re: Grading Plan Review
Proposed Commercial Development
2025 Mer Bleue Road – Phase 2 – Ottawa
to: SmartCentres – Leah Axt - Laxt@smartcentres.com
date: July 23, 2025
file: PG7042-MEMO.01

Paterson reviewed the following drawing prepared by Stantec for the aforementioned development:

- ☐ Grading Plan – 2025 Mer Bleue Road, Ottawa - Project No. 160402122 – Drawing No. GP-1 – Sheet 4 of 7 - Revision 2 dated July 22, 2025.

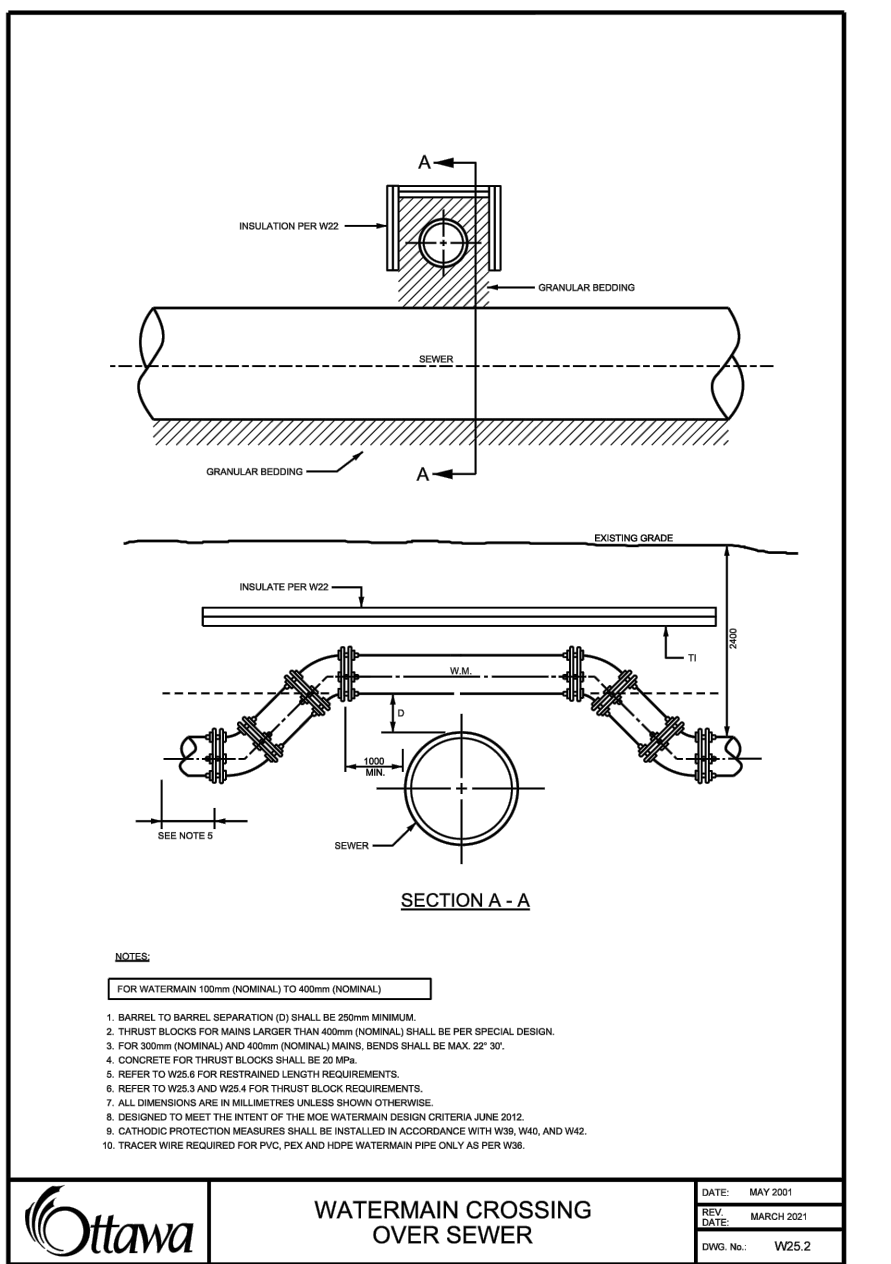
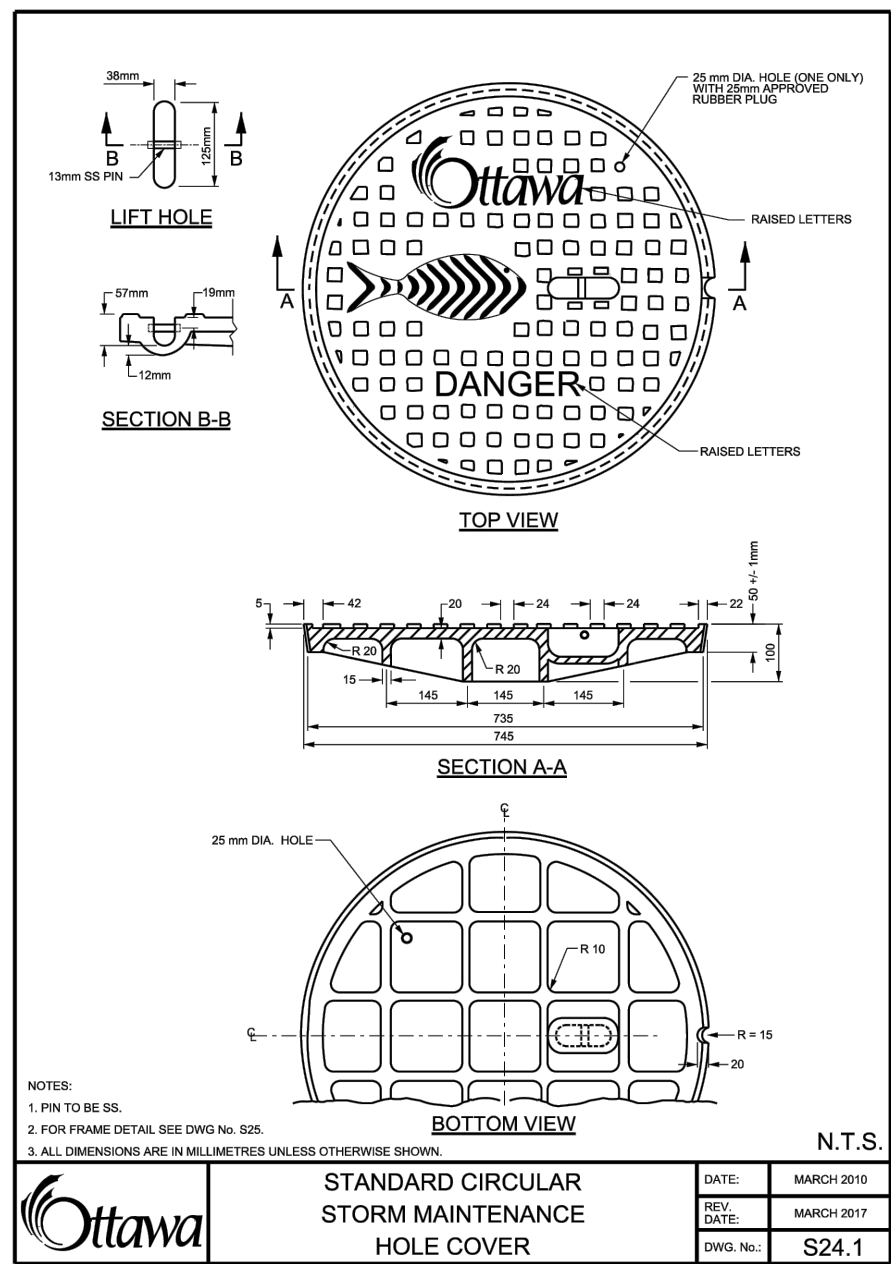
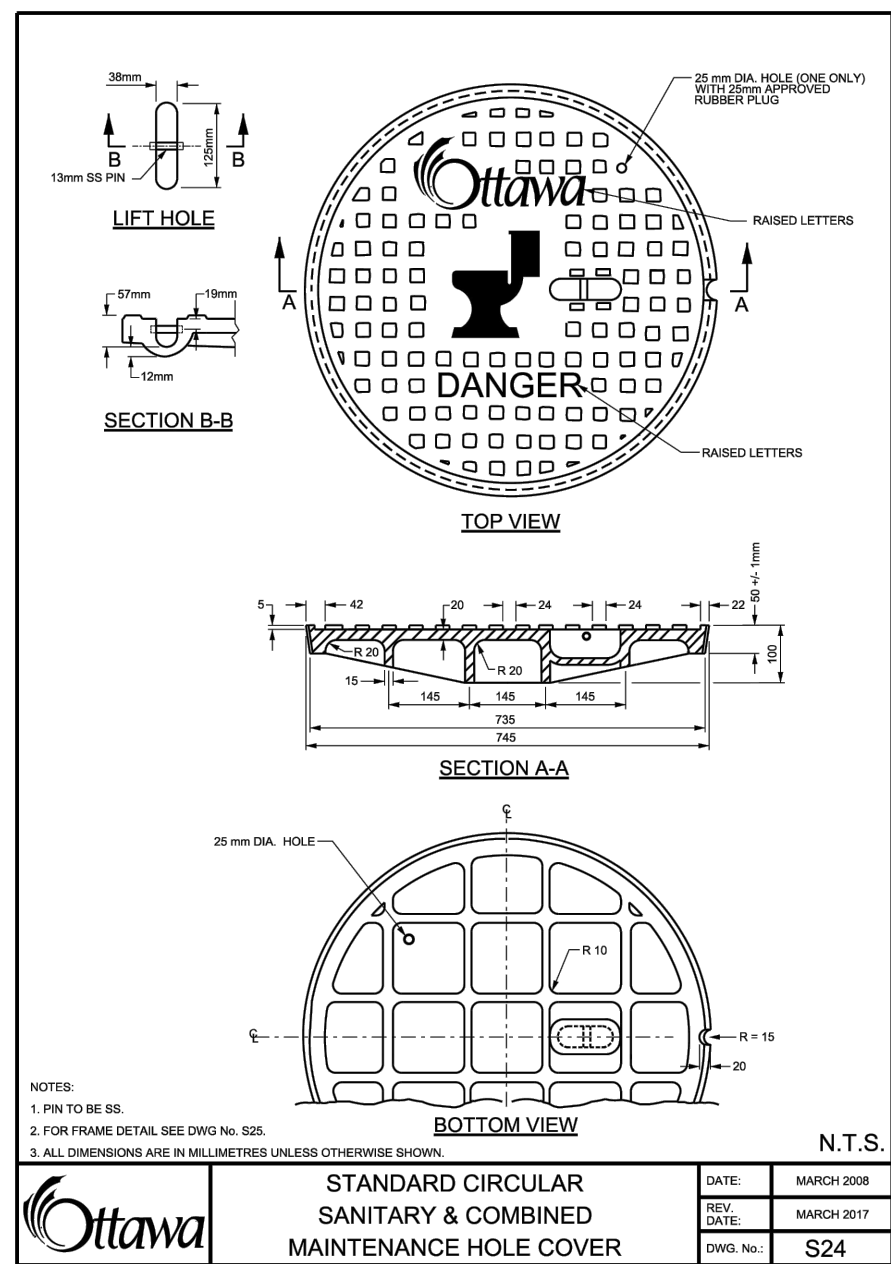
From our review of the above-noted Grading Plan, and on the available soil information, the proposed grades are within the permissible grade raise restriction of 1.8 m inside and within 6 m of the building footprint, and 2.2 m for the parking areas and access lanes. Therefore, the proposed grading is acceptable, from a geotechnical perspective, and no lightweight fill or other considerations to accommodate the proposed grades are required.
